# **Awel y Môr Offshore Wind Farm Examination Review of SLVIA Documents**

**Final report**  
Prepared by LUC  
October 2022

### Awel y Môr Offshore Wind Farm Examination Review of SLVIA Documents

This image provides landscape and visual context only

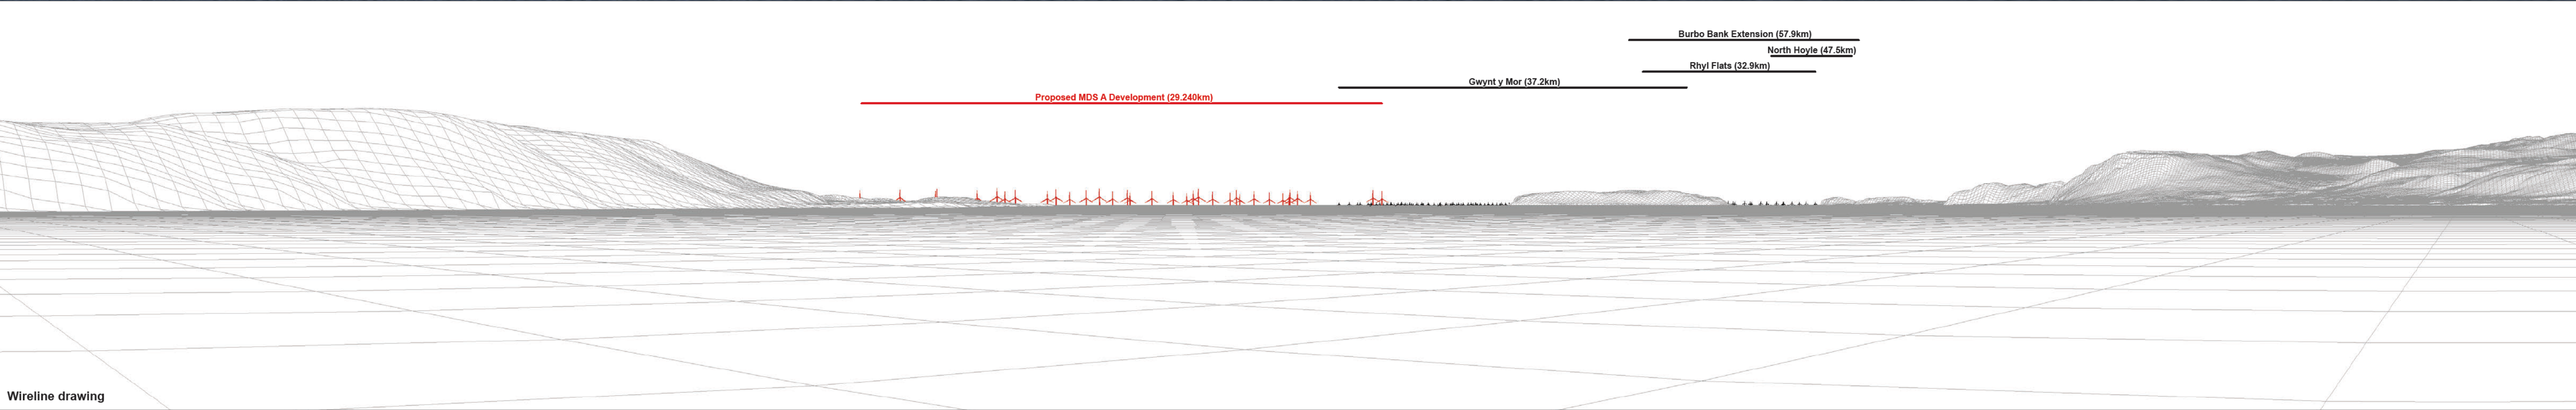
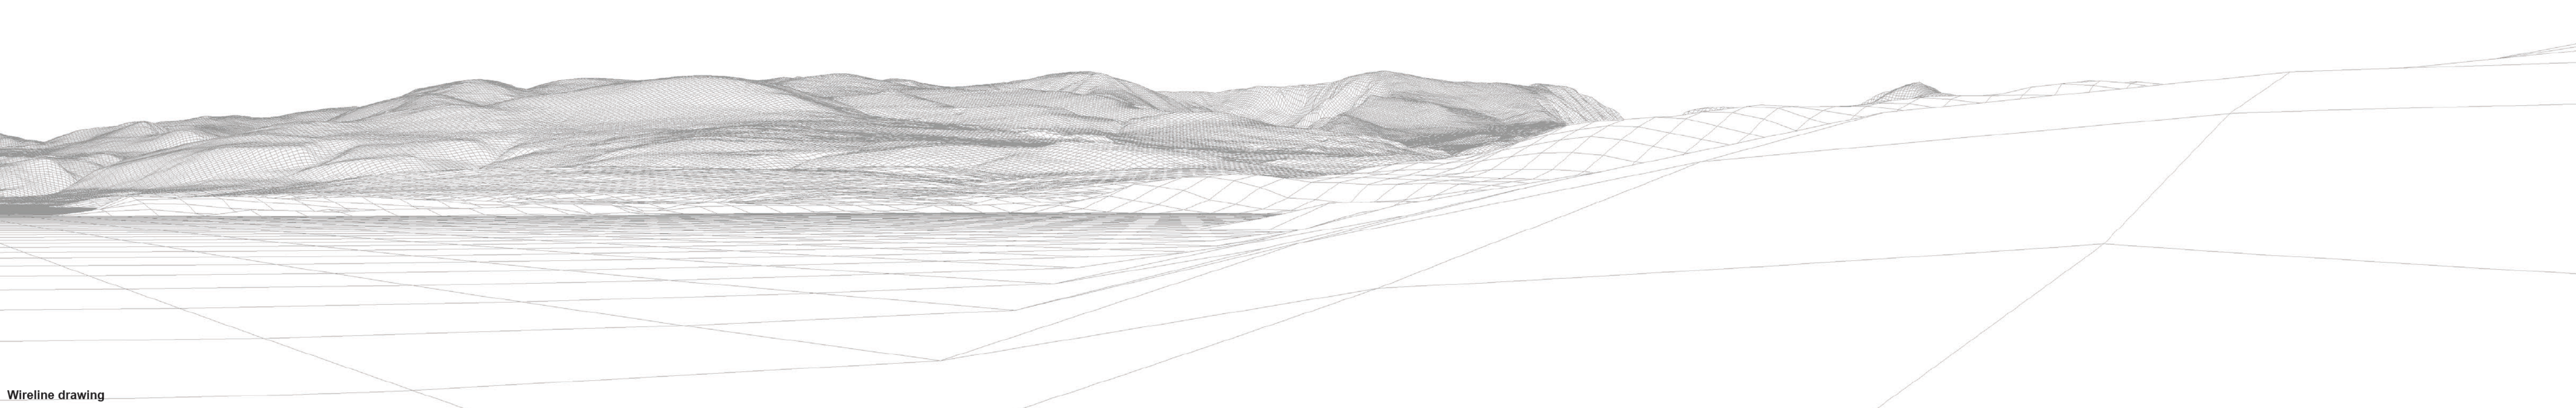
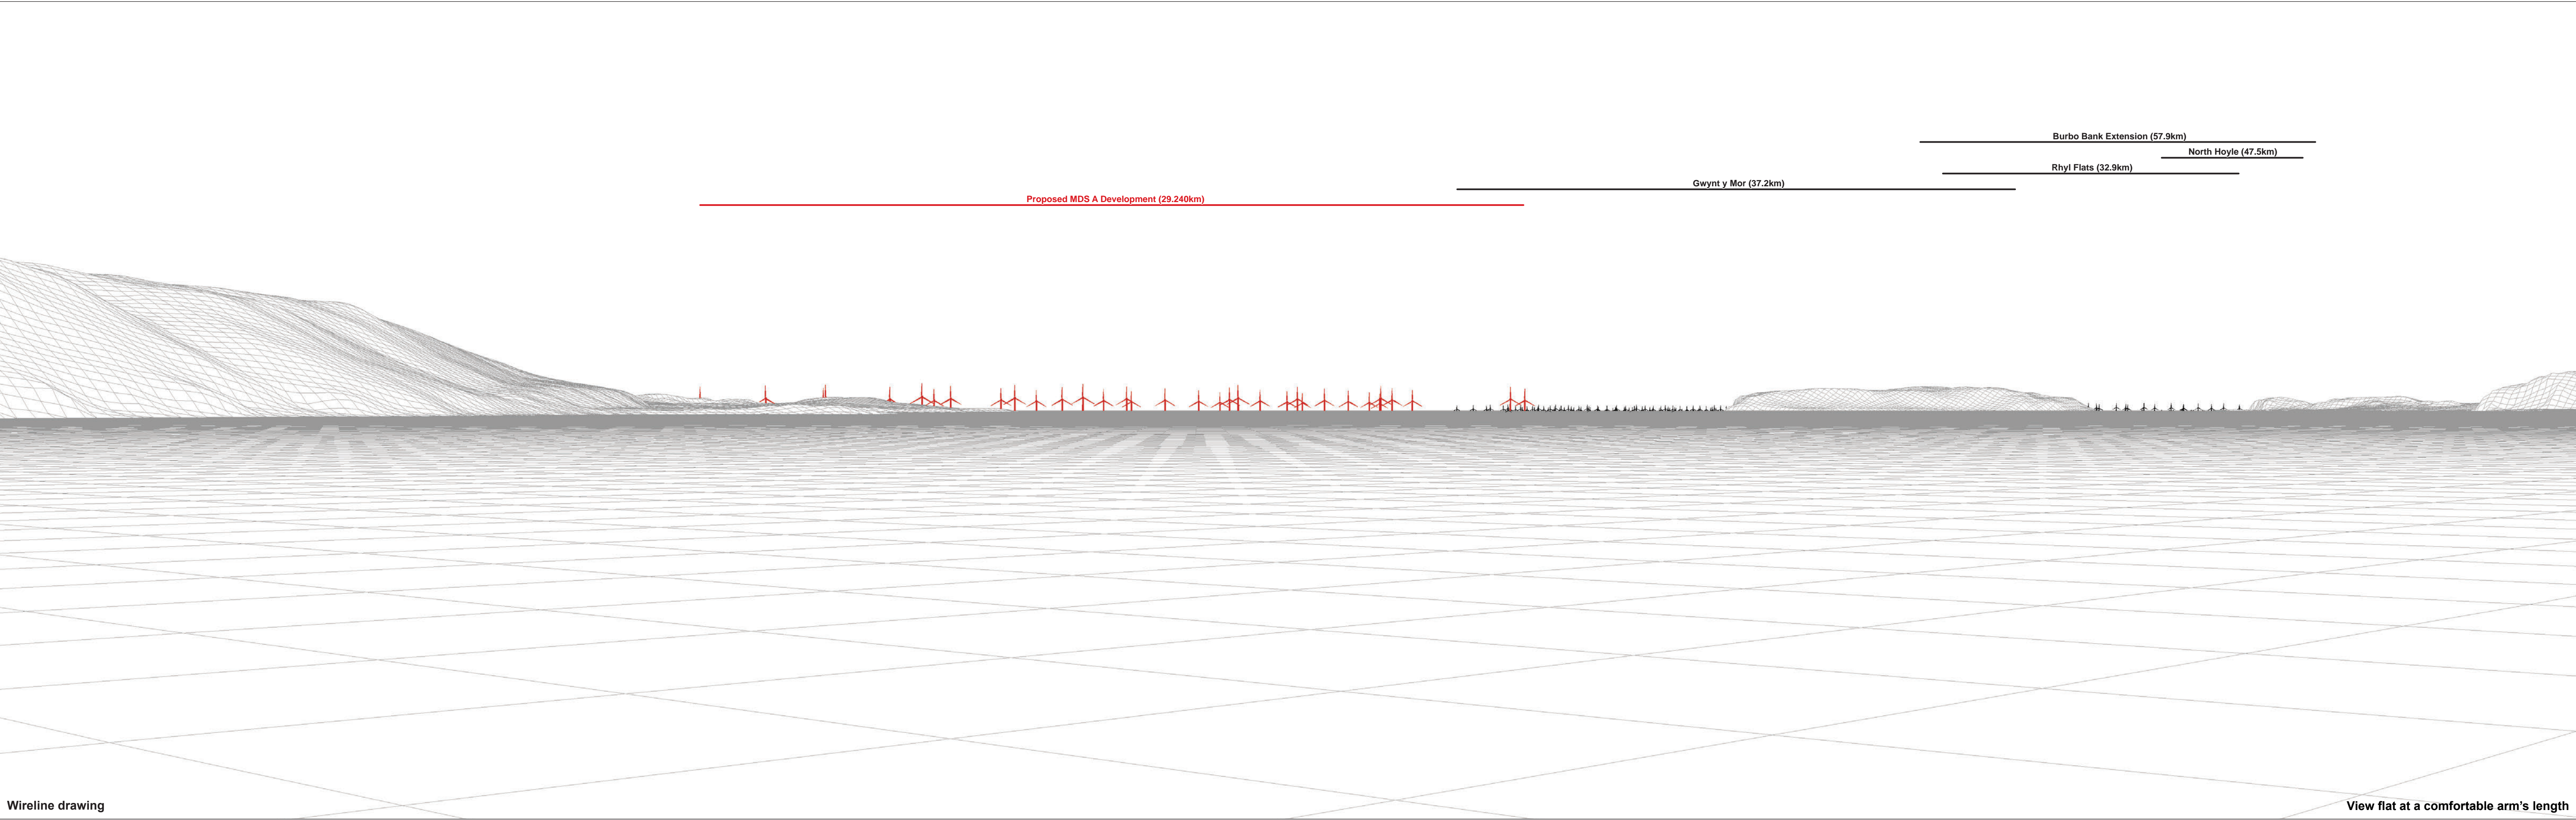
**3.18** We queried the finding of non-significant effects at VP17 Penrhyn Castle Terrace. The SLVIA authors have revisited this in light of stakeholder comments, and a moderate (significant) effect is now recorded. Moderate (significant) effects are also confirmed for VP9 Bangor Pier.
